2020/93308 Former Spotted Cow New Hey Road, Salendine Nook.

Highway Development Management's (HDM) comments for the above application as follows:

Planning application for erection of A1 foodstore with associated parking provision. Access to the site is via the former spotted cow public house entrance taken directly onto the A640 New Hey Road. The site is designated within the Council's Local Plan for housing.

Type D Retaining Wall
Scale 1:50

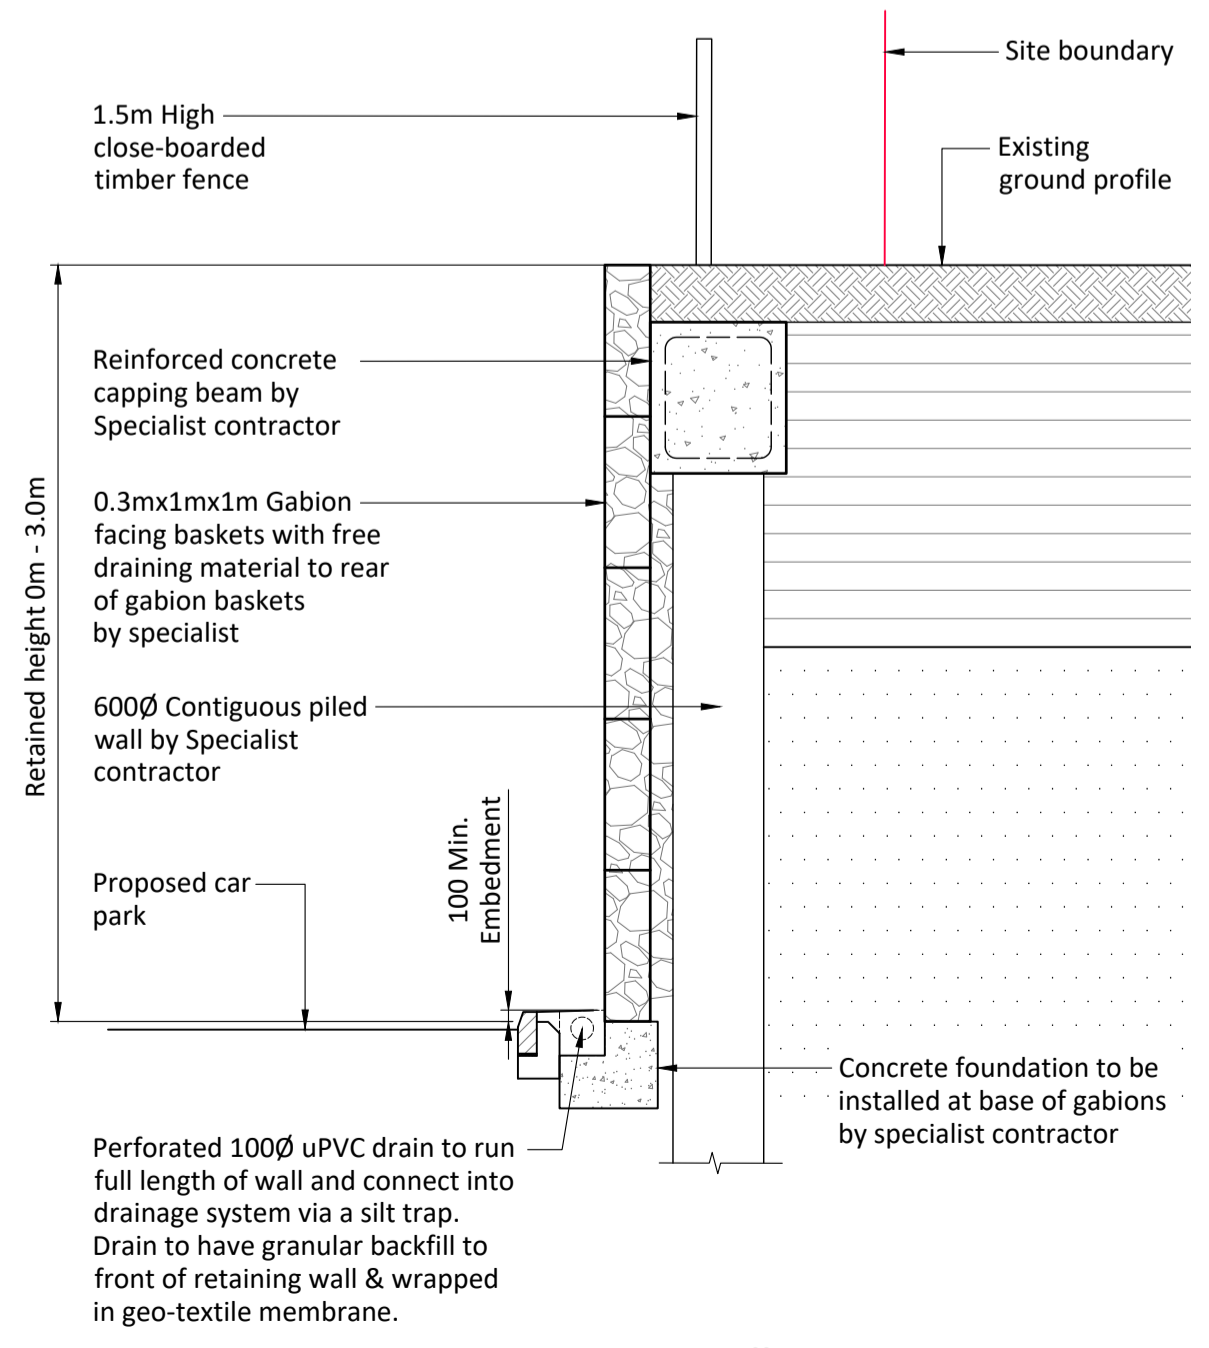
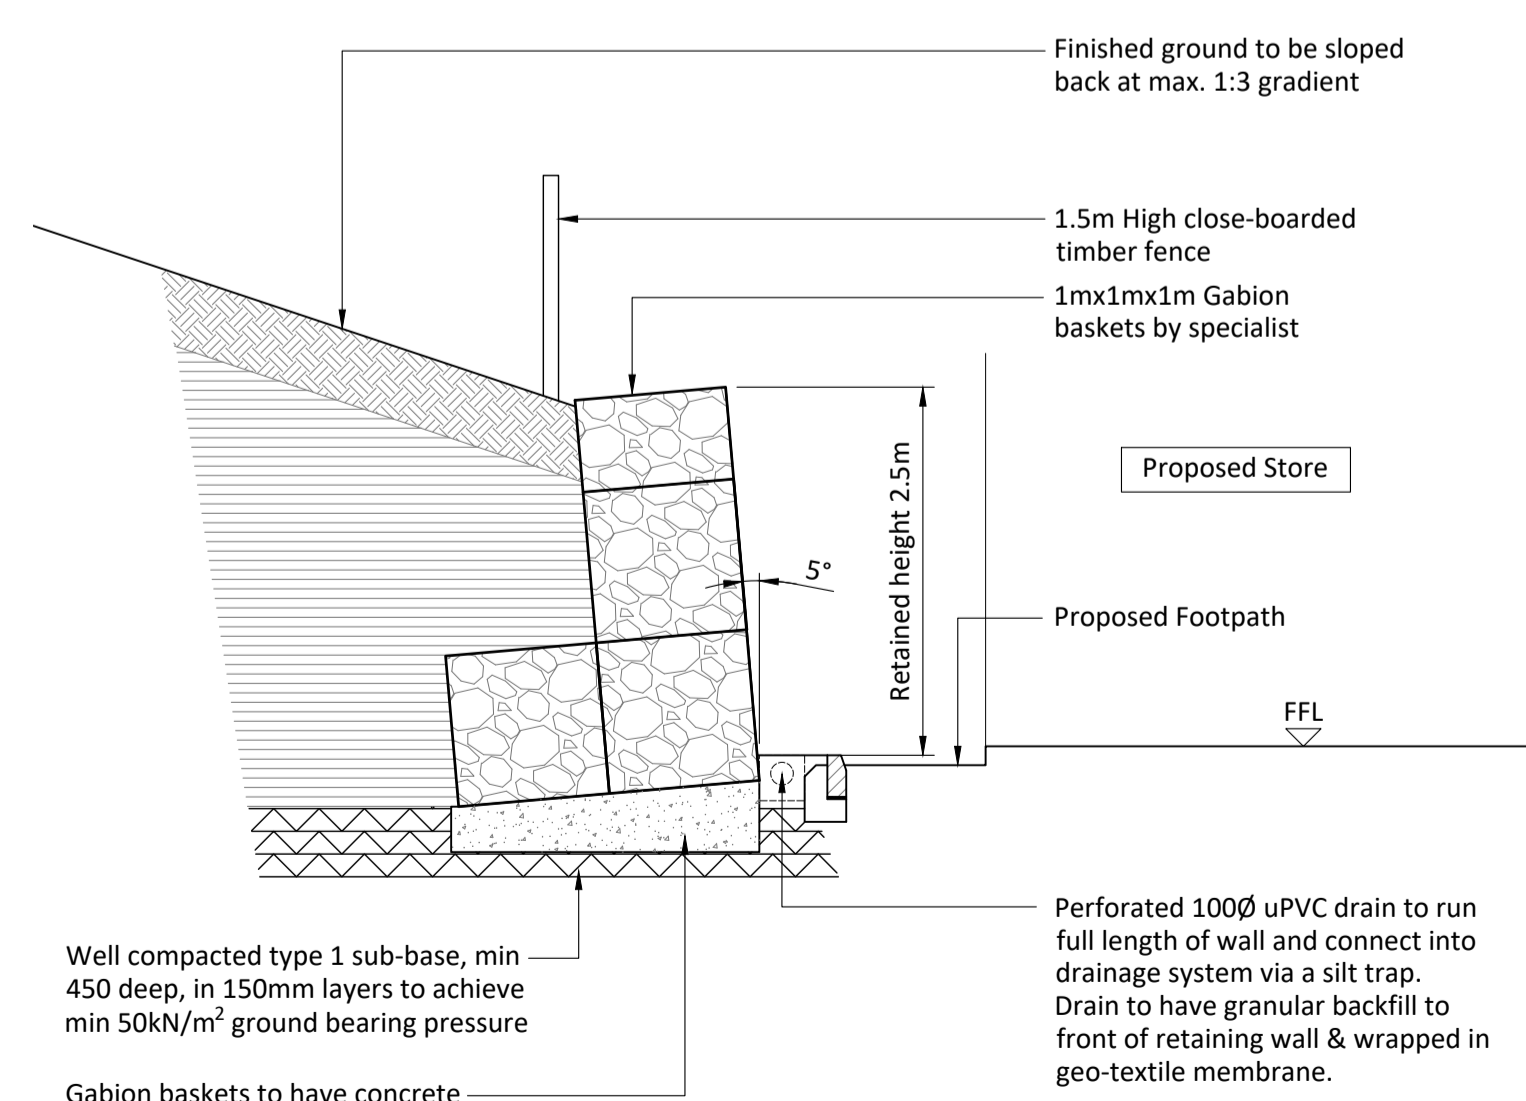
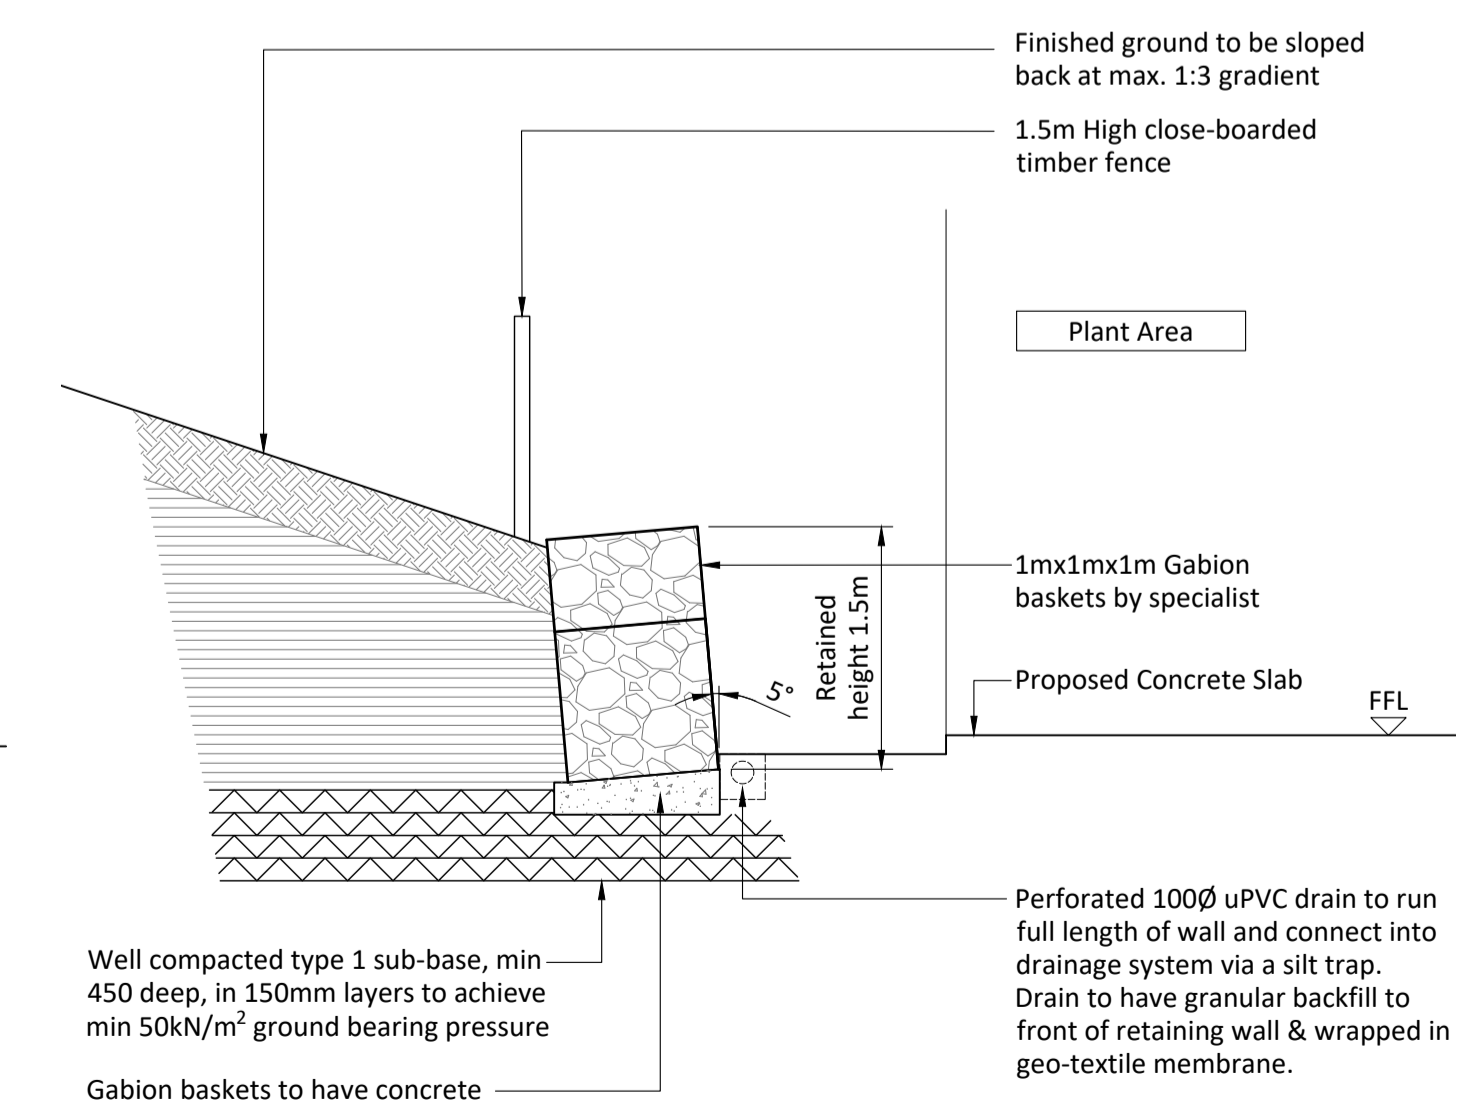
Retaining walls.

Before the development commences a scheme detailing the location and cross sectional information together with the proposed design and construction for all new retaining walls/ building walls adjacent to the existing/ proposed adoptable highways including any modifications to the existing retaining wall supporting the A640 New Hey Road and or PROW 367 shall be submitted to and approved by the Highway Authority in writing. The approved scheme shall be implemented prior to the commencement of the proposed development and thereafter retained during the life of the development.
